**KIRKLEES METROPOLITAN COUNCIL  
INVESTMENT & REGENERATION SERVICE**

**DELEGATED DECISION TO DETERMINE PLANNING APPLICATIONS**

Reference No:	<b>2024/62/90224/E</b>
Site Address:	20, Park View, Thornhill Lees, Dewsbury, WF12 9DT
Description:	Erection of two storey extension with a front dormer and associated alterations
Recommending Officer:	Jennifer Booth

## **OFFICER REPORT**

| PHASE<br>Planning Application                   | SCALE<br>1:100 @ A3 | SHEET NO.<br>AR-03            | PROJ.NO.<br>C23057 |

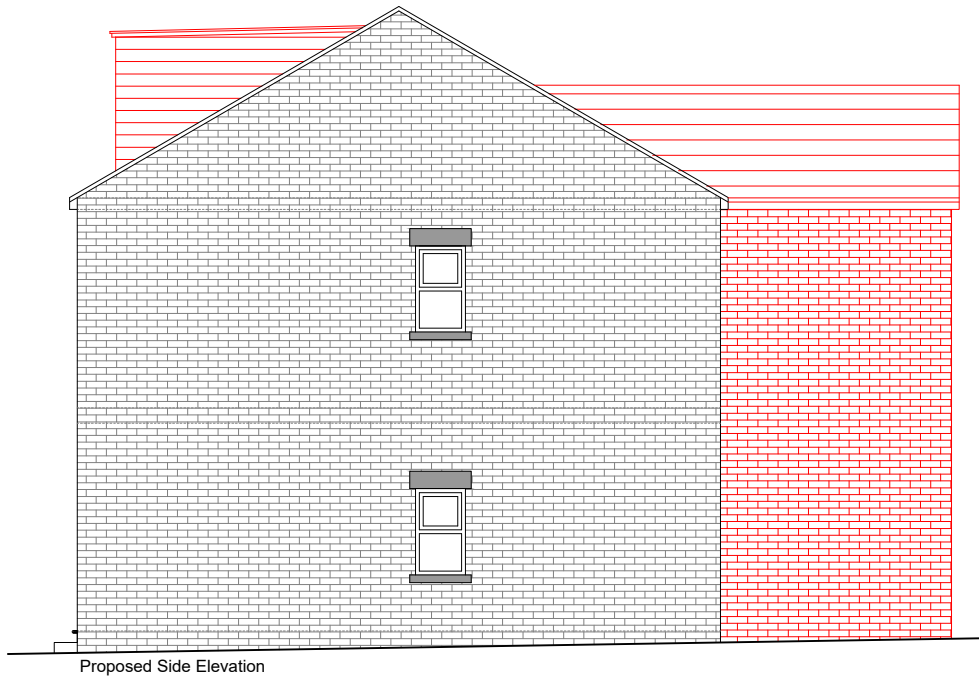
The front dormer would be centrally sited within the roof plane with a modest width. The plans show the use of horizontal cladding. However, colour finish has not been specified. To ensure a satisfactory appearance, it is considered to be reasonable to condition the finish is a grey. The front dormer, subject to condition, is considered to be acceptable in terms of visual amenity.

The colour finish of the cladding should be conditioned to be a grey colour to minimise the visual impact.

The initially submitted plans raised concerns in terms of the size of the front dormer, the use of a rear dormer and the impact of the rear extension on the adjoining dwelling. Amended plans have been sought and received which reduced the front dormer, removed the rear dormer and reduced the width of the rear extension. As the alterations reduced the level of development, the amended plans have not been advertised.

4. Notwithstanding the submitted details the front dormer hereby approved shall be clad with a grey boarding and thereafter retained.

PROJECT NAME 20 Park View WF12 9DT			
DRAWING TITLE Existing & Proposed Floor Plans		DRAWN BY/ CHECKED BY MR/MS	
PHASE Planning Application	SCALE 1:100 @ A3	SHEET NO. AR-02	PROJ.NO. C23057

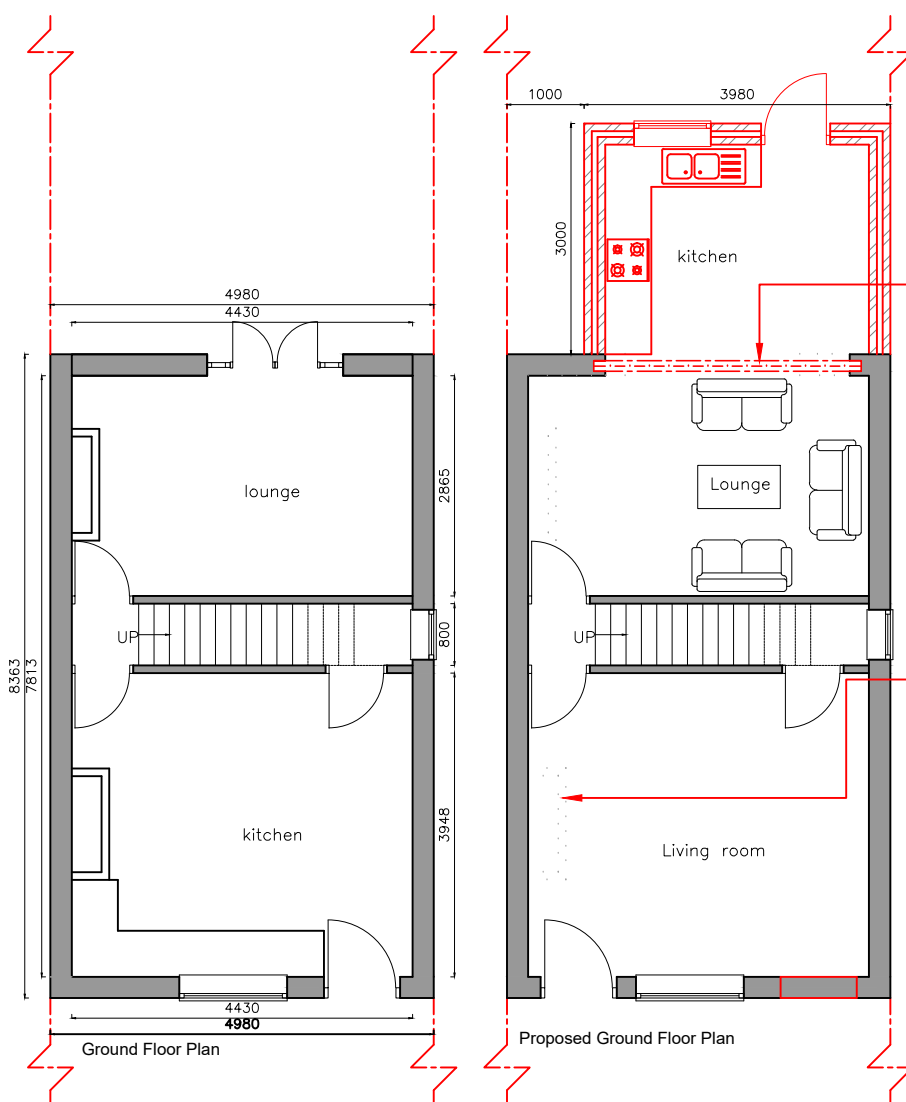
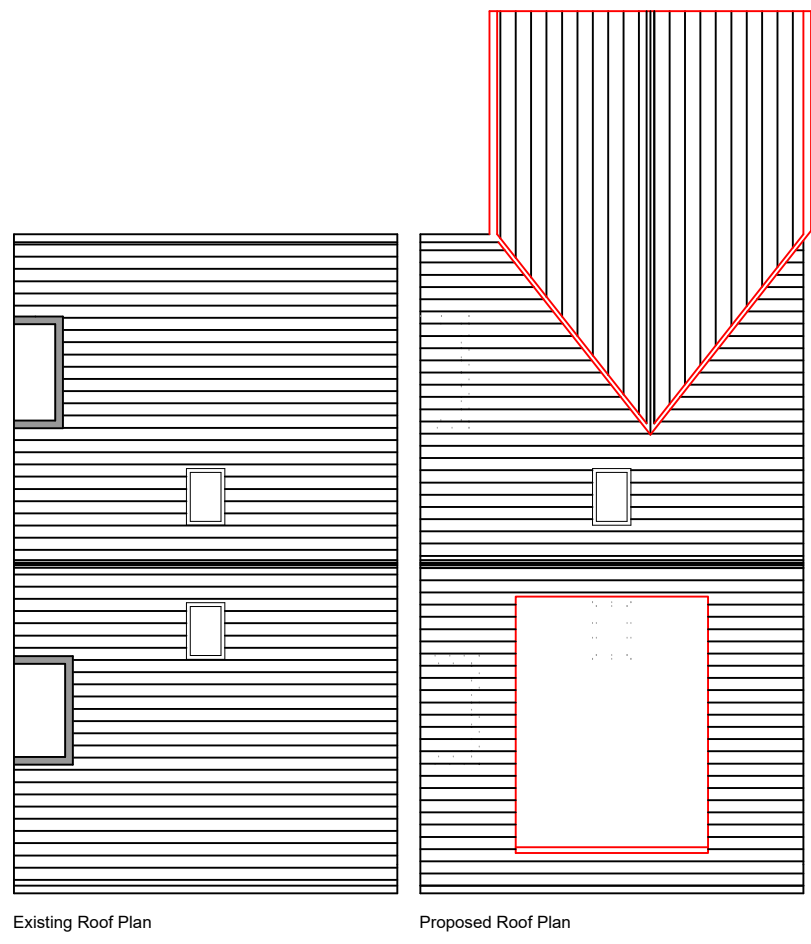
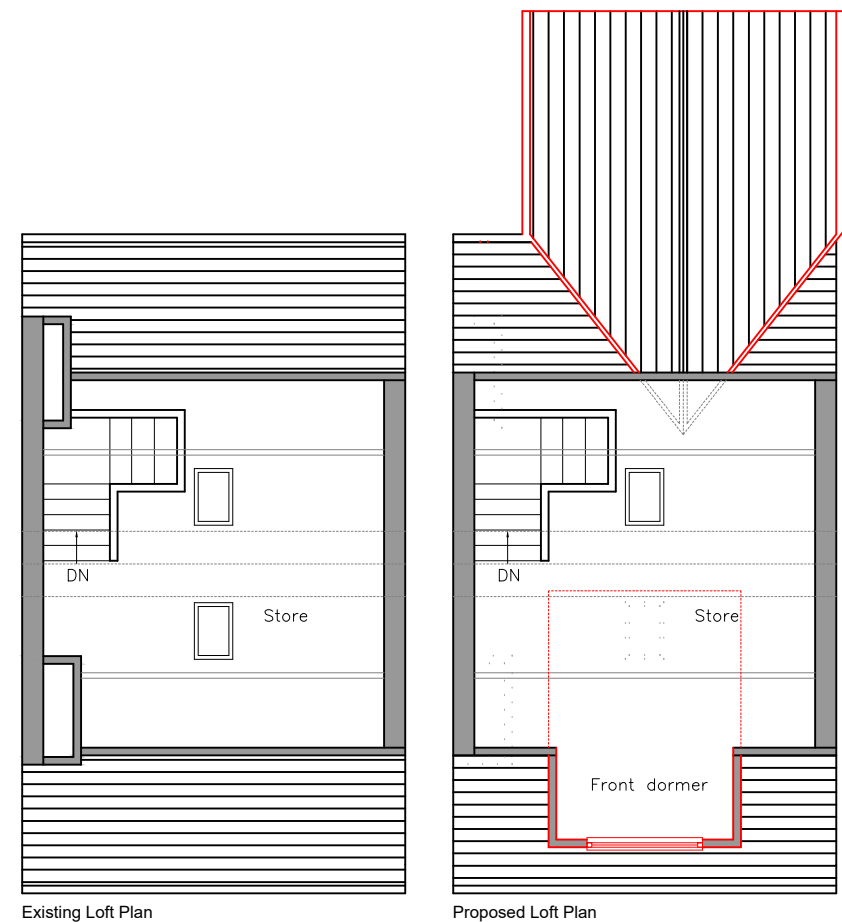
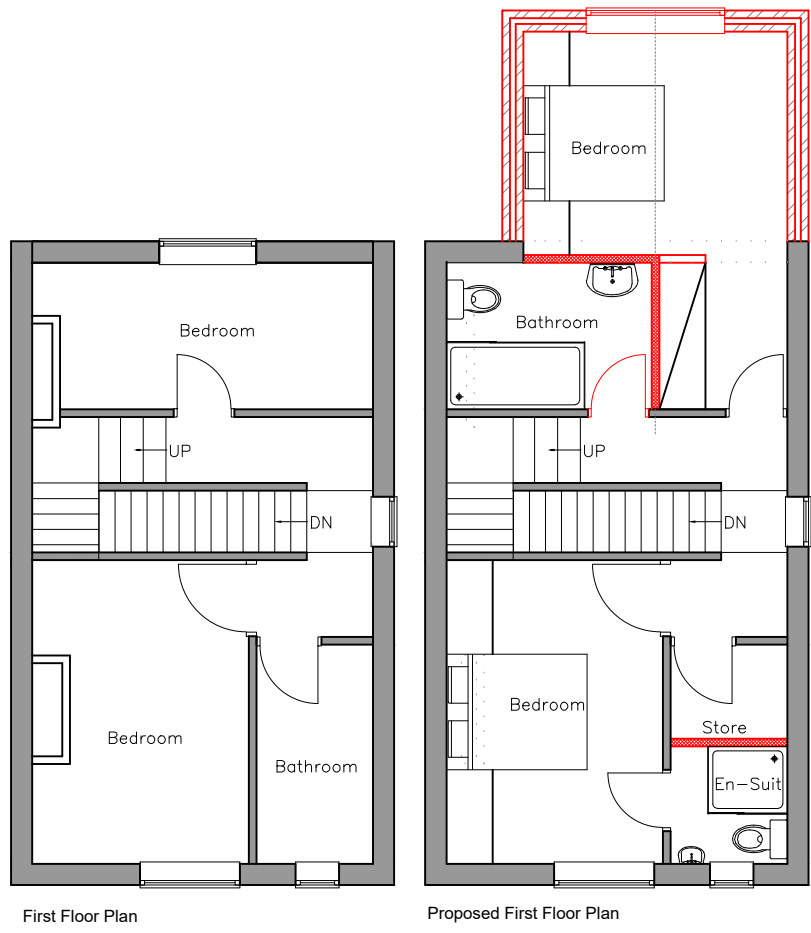
The rear extension would be set back 1m from the shared boundary. The agent has supplied a floor plan which shows the 45 degree relationship with the neighbour's windows which is considered to be acceptable. The impact in terms of overshadowing or overbearing is considered to be limited. The windows would look into the applicants own garden with limited potential for loss of privacy.
